Ecological comments

Application: 3/2013/0307

Proposals: Application for approval of reserved matters following outline approval for the erection of 58 no. dwellings including details of details of layout, scale, appearance and landscaping

Location: Land Off Preston Road Longridge Lancashire

Proposal site pond

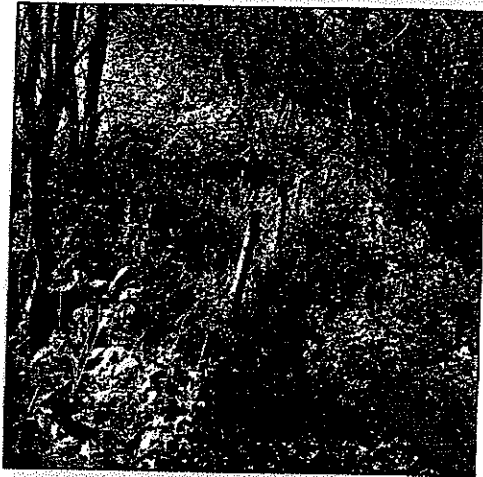
Currently submitted plans do not appear to show any habitat retained (indeed the layout is less favourable to biodiversity maintenance than the outline proposals). It is not clear that the pond would be retained or enhanced, and there does not appear to be any provision for amphibians within the proposed layout. It appears that habitat connectivity would be reduced as a result of the proposed layout, which I note varies from that submitted at the outline stage and which had appeared to better maintain habitat connectivity.
